Re: Letter of Intent Verizon CSP Scarebrook

Verizon Wireless is requesting approval to Co-Locate antennas and equipment on the existing CMRS facility at 17995 Sierra Way, Monument, CO 80132.

EXISTING  
WALL HATCH  
NEW WORK/  
UTILITY EASEMENT  
ACCESS/UTILITY  
EASEMENT  
HYBRID CABLE/COAX  
DC POWER  
FIBER  
ANTENNAS  
RR/HBBU  
LEASE AREA  
EXISTING  
EASEMENT  
PENETRATIONS

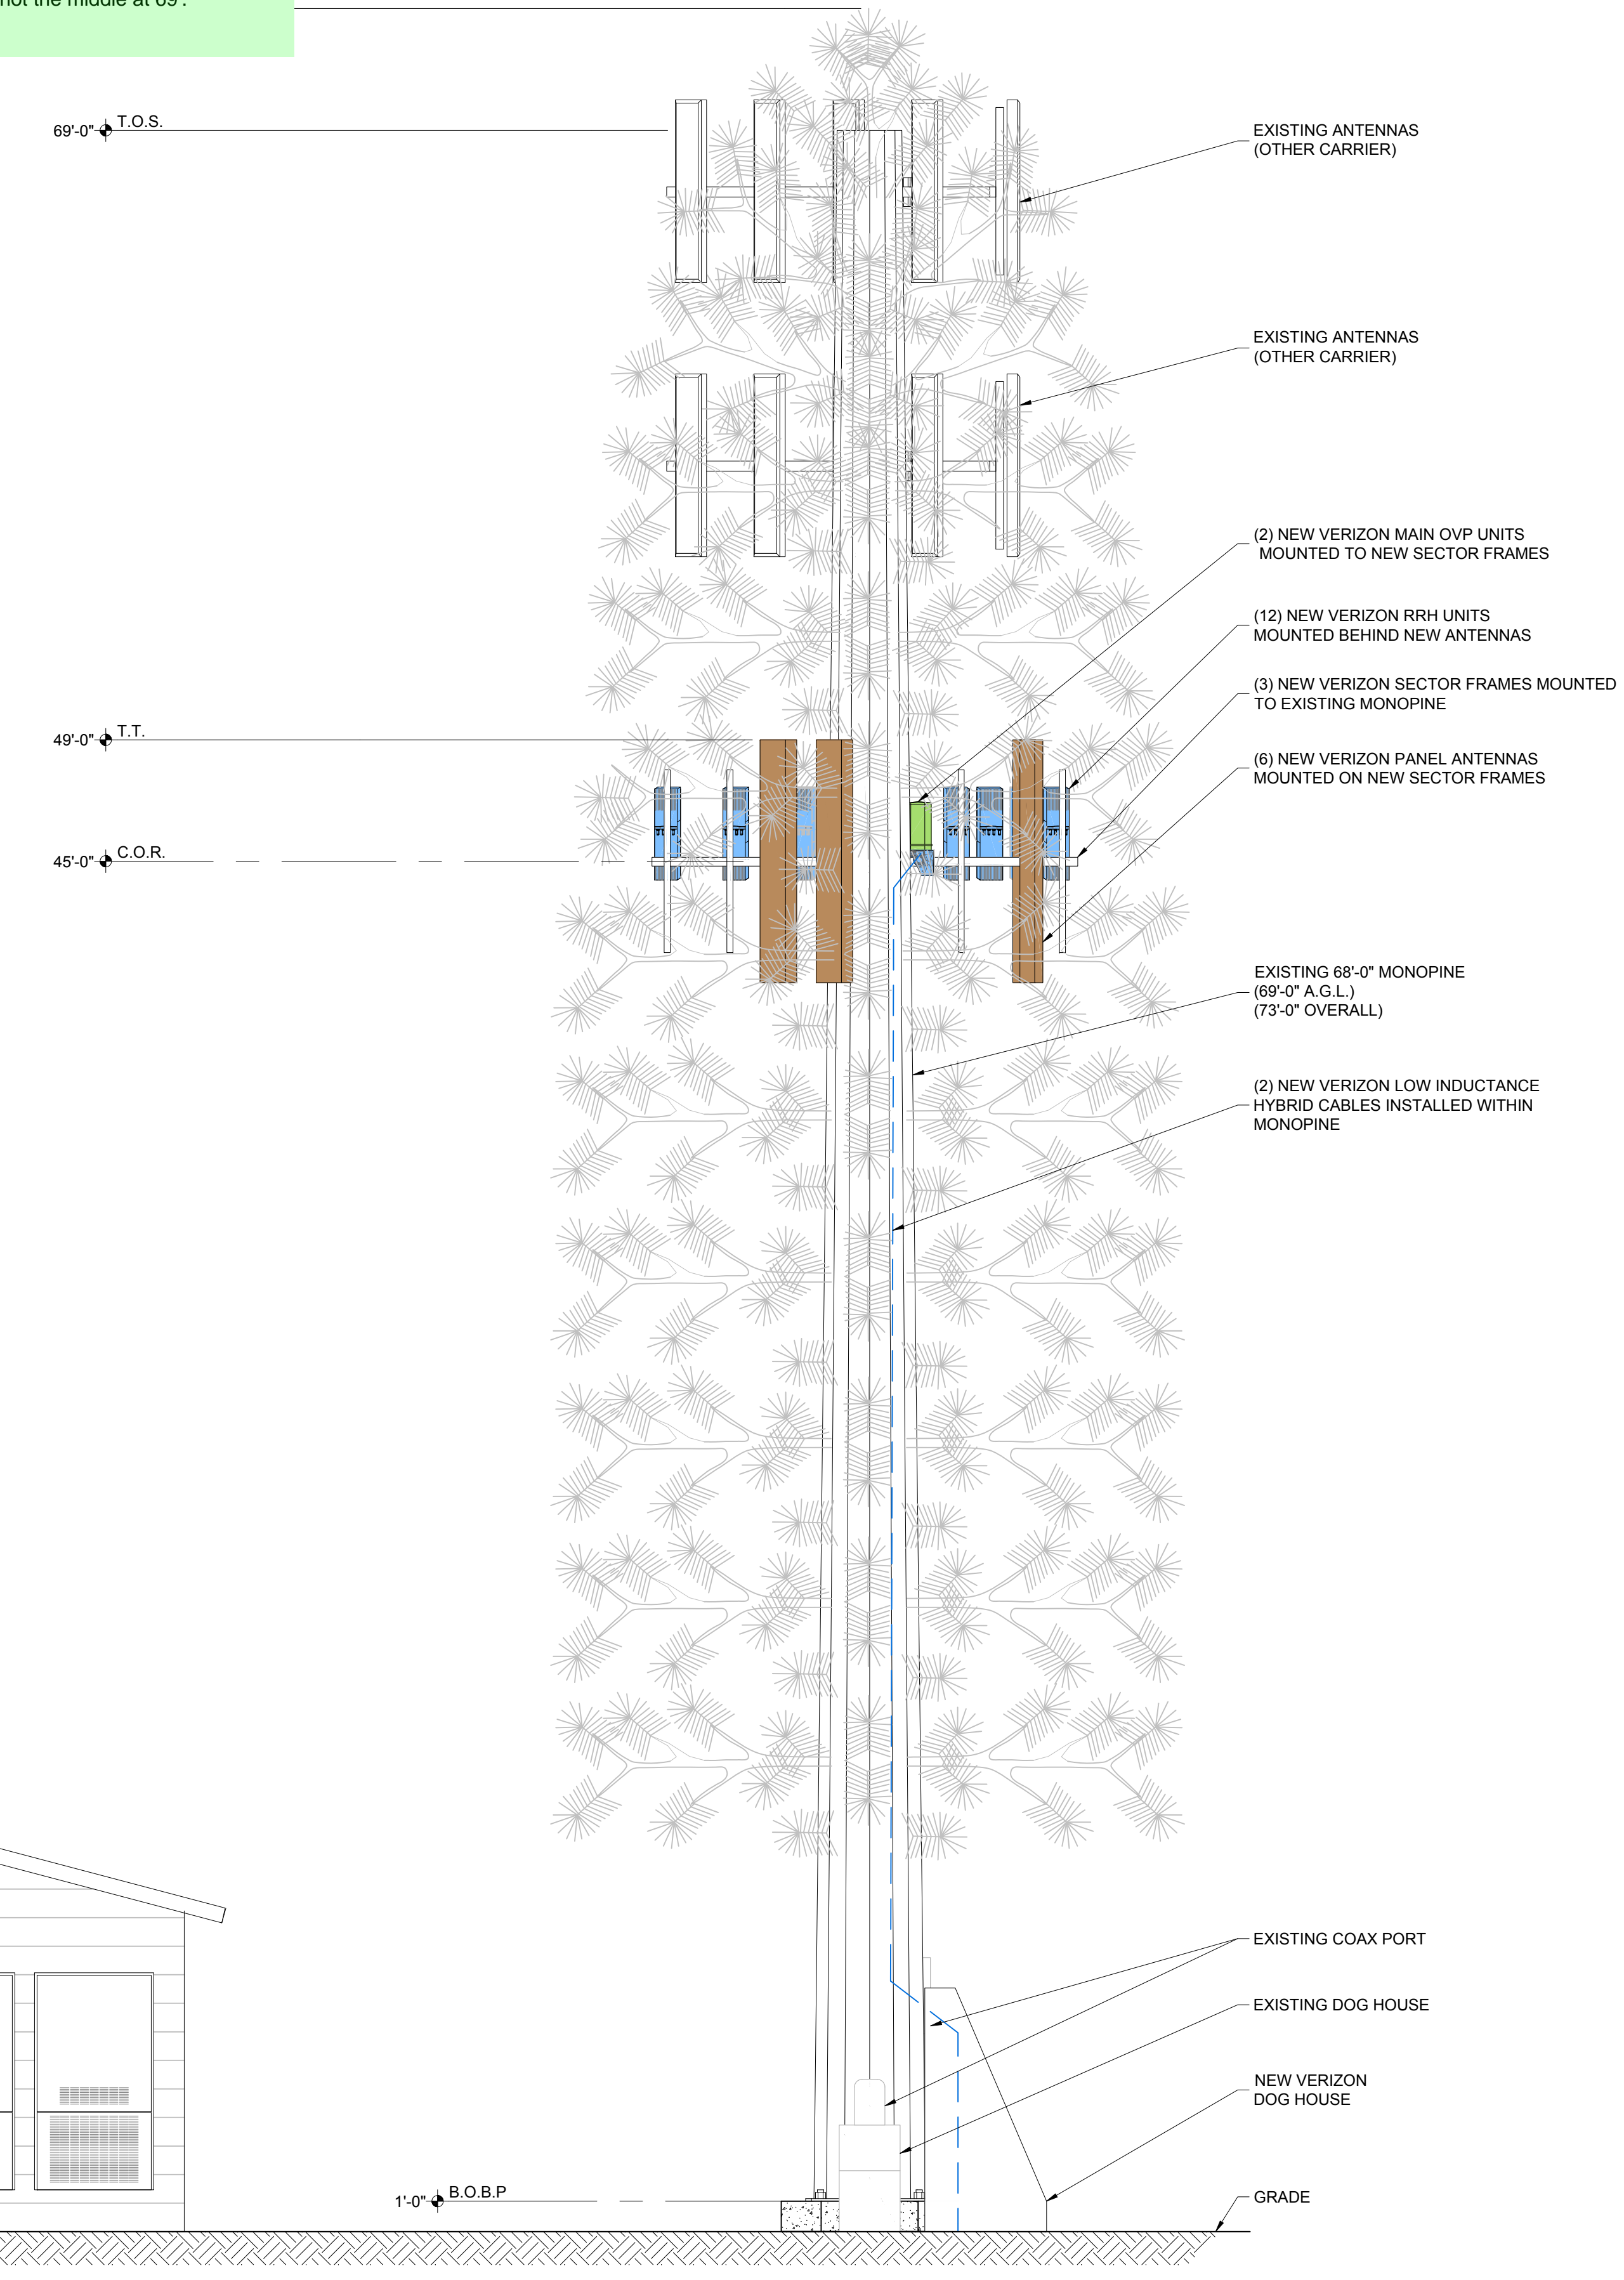
Does this mean it will not extend to 55' or to 80', because in no way is this allowed to go taller than 70 feet.
